58 Gertrude 402-D-003

BP# 2011-08-1835

ONE AND TWO FAMILY	PLAN REVIEW	CHECKLIST		
Soil type/Presumptive Load Value (Table R401.4.1)				
Component	Submitted Plan	Findings	Revisions	Date
STRUCTURAL Footing Dimensions/Depth (Table R403.1 & R403.1(1), (Section R403.1 & R403.1.4.1)	114" x 10" Footing bottom 4' min 2' x 12" interior 4" slab			
Foundation Drainage, Fabric, Damp proofing (Section R405 & R406)	Notes: Sealer/damp proof	? drain pipe, fabric		①
Ventilation/Access (Section R408.1 & R408.3) Crawls Space ONLY	N/A			
Anchor Bolts/Straps, spacing (Section R403.1.6)	5/8" x 12" J hook 3' oc. corners			
Lally Column Type (Section R407)	3 1/2" steel w/ concrete			
Girder & Header Spans (Table R 502.5(2))	7'10" $\xrightarrow{\text{L FLOOR CTR BEARING}}$	7'5" max allowed		②
Built-Up Wood Center Girder Dimension/Type	3-2x10			
Sill/Band Joist Type & Dimensions	2x10 / 2x6 PT			
First Floor Joist Species Dimensions and Spacing (Table R502.3.1(1) & Table R502.3.1(2))	2x10 16" O.C. Right side 2x10 12" O.C. Left side

HANDRAIL DETAIL NTS

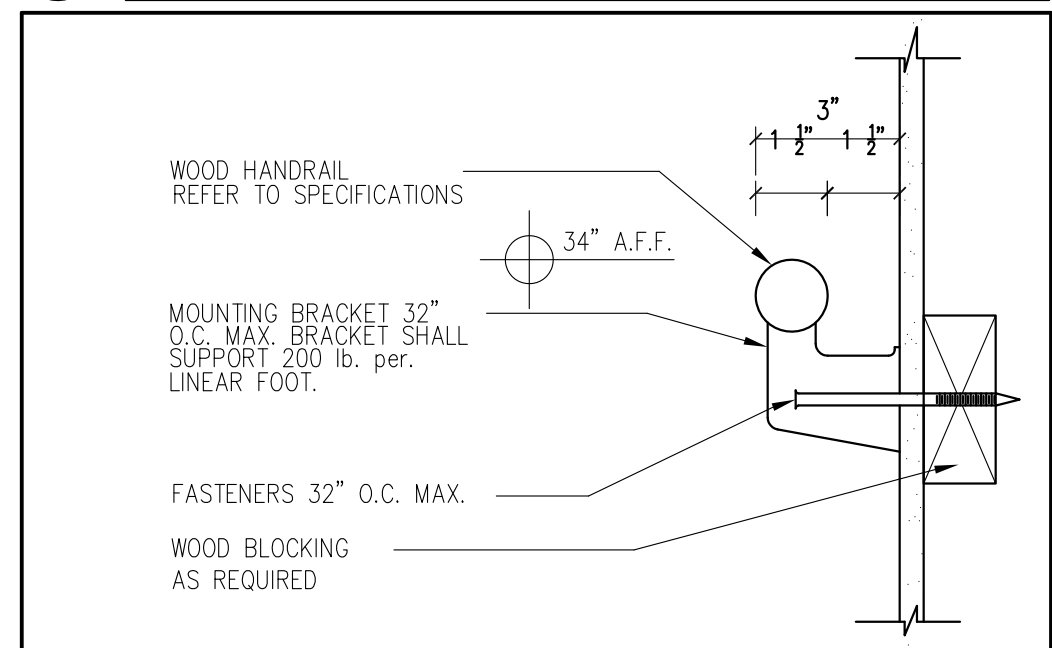
Type of Heating System		
Means of Egress (Sec R311 & R312) Basement	yes - bulkhead	
Number of Stairways	4	
Interior	2	
Exterior	2	R311.7.5 NOT showing landing & details (stairs) Shows on site plan
Treads and Risers (Section R311.5.3)	Int. 7 3/4" R 10" T 2 9/16" "	
Width (Section R311.5.1)		
Headroom (Section R311.5.2)	6'8"	
Guardrails and Handrails (Section R312 & R311.5.6 - R311.5.6.3)	34" handrail	
Smoke Detectors (Section R313) Location and type/Interconnected	General notes for compliance	
Draftstopping (Section R502.12) and Fireblocking (Section (R602.8)		
Dwelling Unit Separation (Section R317) and IBC - 2003 (Section 1207)	N/A	
Deck Construction (Section R502.2.1)	10' x 10' 3-2x10 beams 4'7" 2x10 16' oc.	Lateral Attachment Detail Ground HT & openings dimension

SECTION THRU HOUSE
 SCALE : 1/4" = 1' - 0"

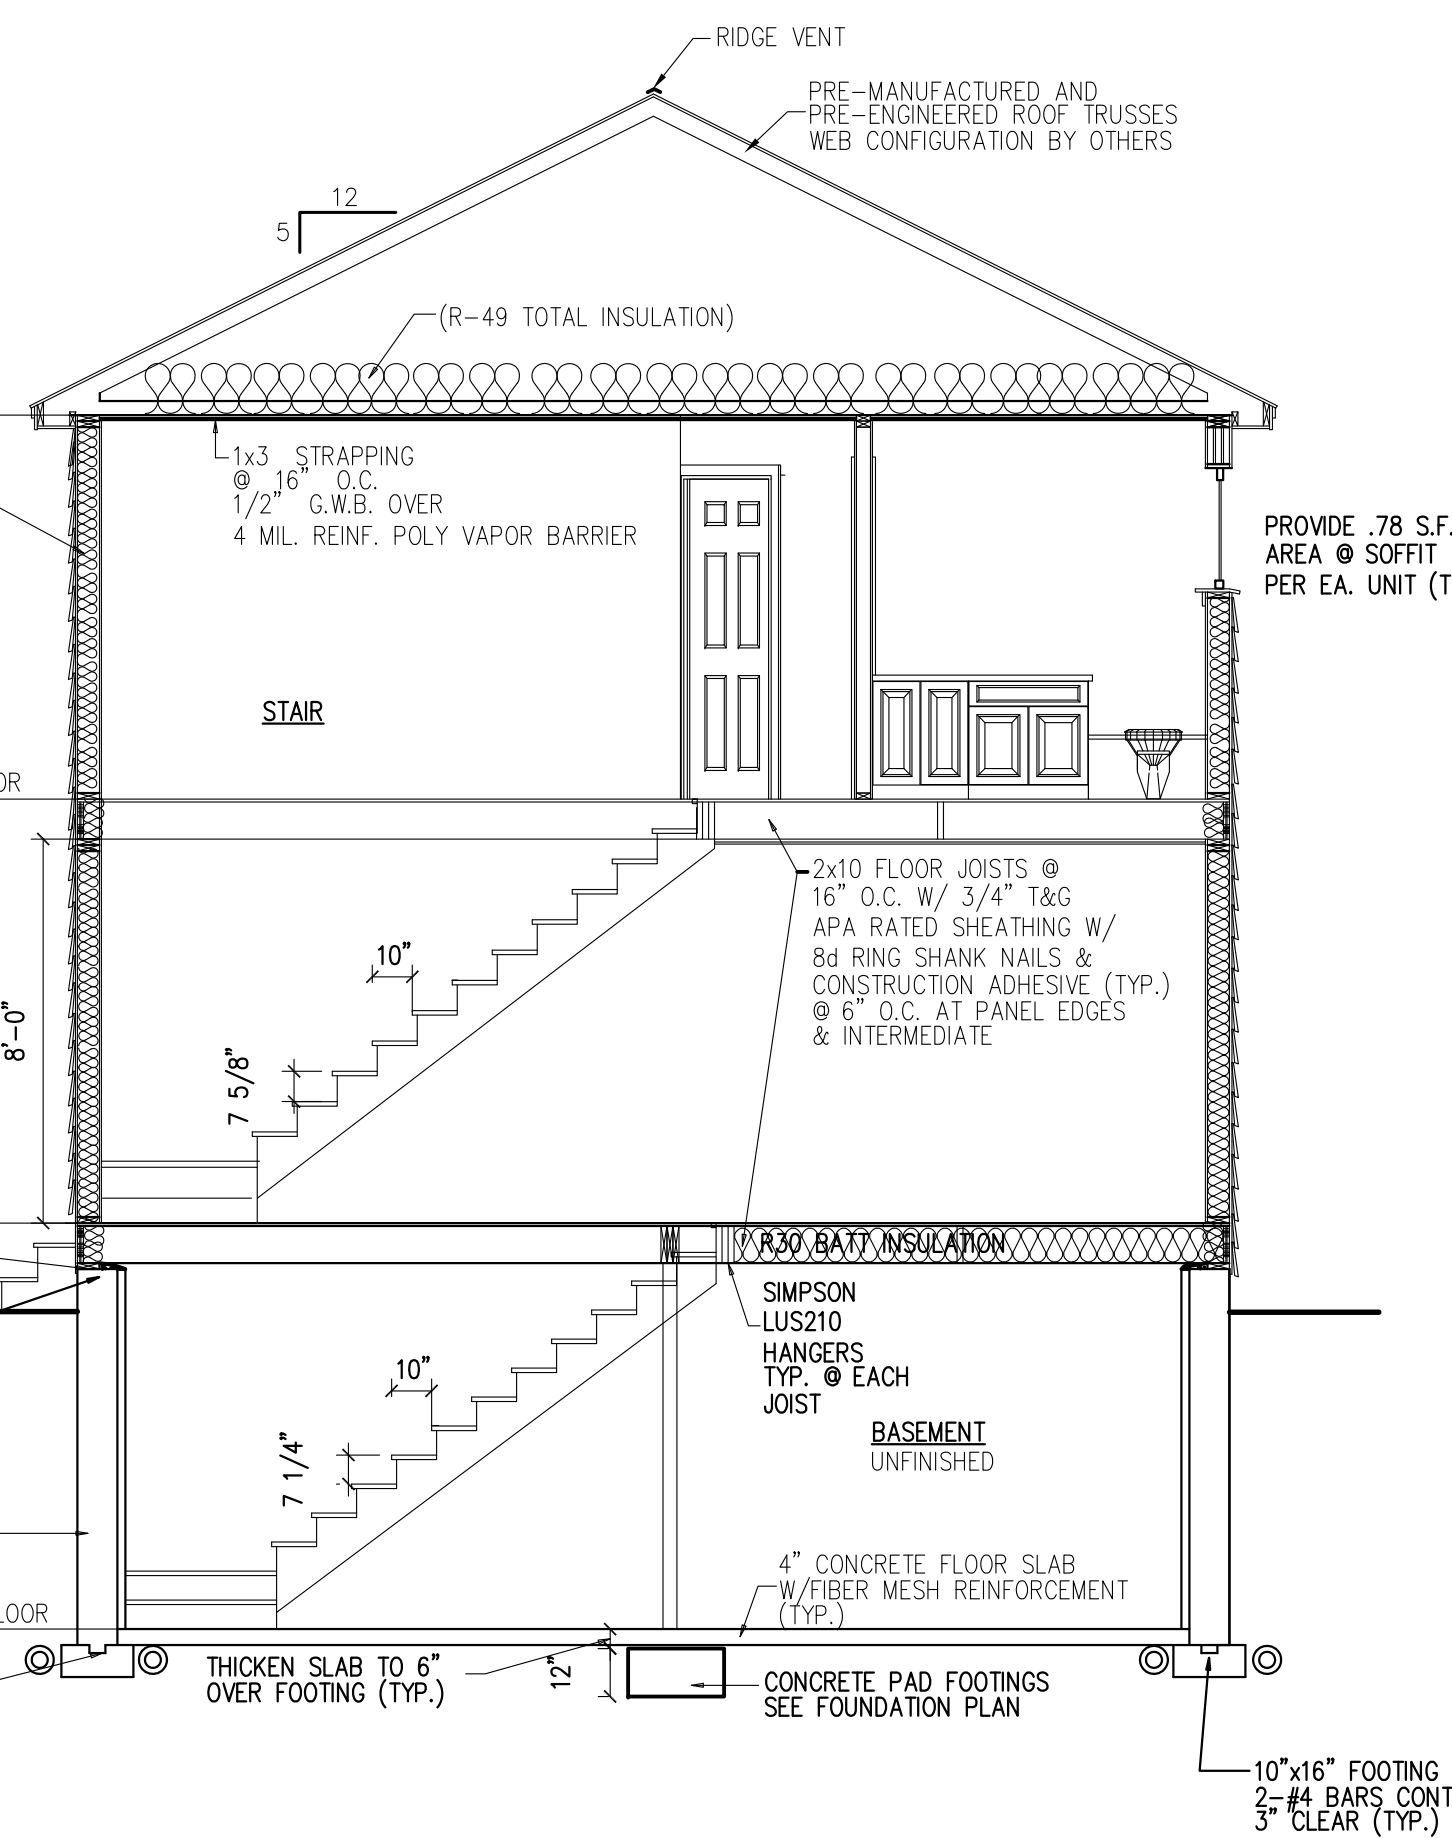
Second Floor Joist Species Dimensions and Spacing (Table R502.3.1(1) & Table R502.3.1(2))	2x10 16" OC			
Attic or additional Floor Joist Species Dimensions and Spacing (Table R802.4(1) and R802.4(2))	ceiling ties	? NO dimension given size		③

Pitch, Span, Spacing & Dimension (Table R802.5.1(1) - R 802.5.1(8)) Roof Rafter; Framing & Connections (Section R802.3 & R802.3.1)	2x10 - 12'4 2x8 - 12'12 2x12 ridge	Note pre-man Truss remove if not using	④
Sheathing; Floor, Wall and roof (Table R503.2.1.1(1))	3/4" T+G, 1/2" ply or 7/16 APA, 5/8 APA		
Fastener Schedule (Table R602.3(1) & (2))	As noted		
Private Garage (Section R309) Living Space ? (Above or beside) Fire separation (Section R309.2) Opening Protection (Section R309.1)	N/A		
Emergency Escape and Rescue Openings (Section R310)	36" x 24" Egress eal/bdrm		
Roof Covering (Chapter 9)	25yr Fiberglass		
Safety Glazing (Section R308)	N/A		
Attic Access (Section R807)	N/A		
Chimney Clearances/Fire Blocking (Chap. 10)	Shows 2" clearance	disclosure condition	
Header Schedule (Section 502.5(1) & (2))	1st FL bearing wall & schedule 8' & 5' wall openings	8' 6 1/2" allowed ok	
Energy Efficiency (N1101.2.1) R-Factors of Walls, Floors, Ceilings, Building Envelope, U-Factor Fenestration		Need Res check Certification OR REVISION for IECC compliance	⑤
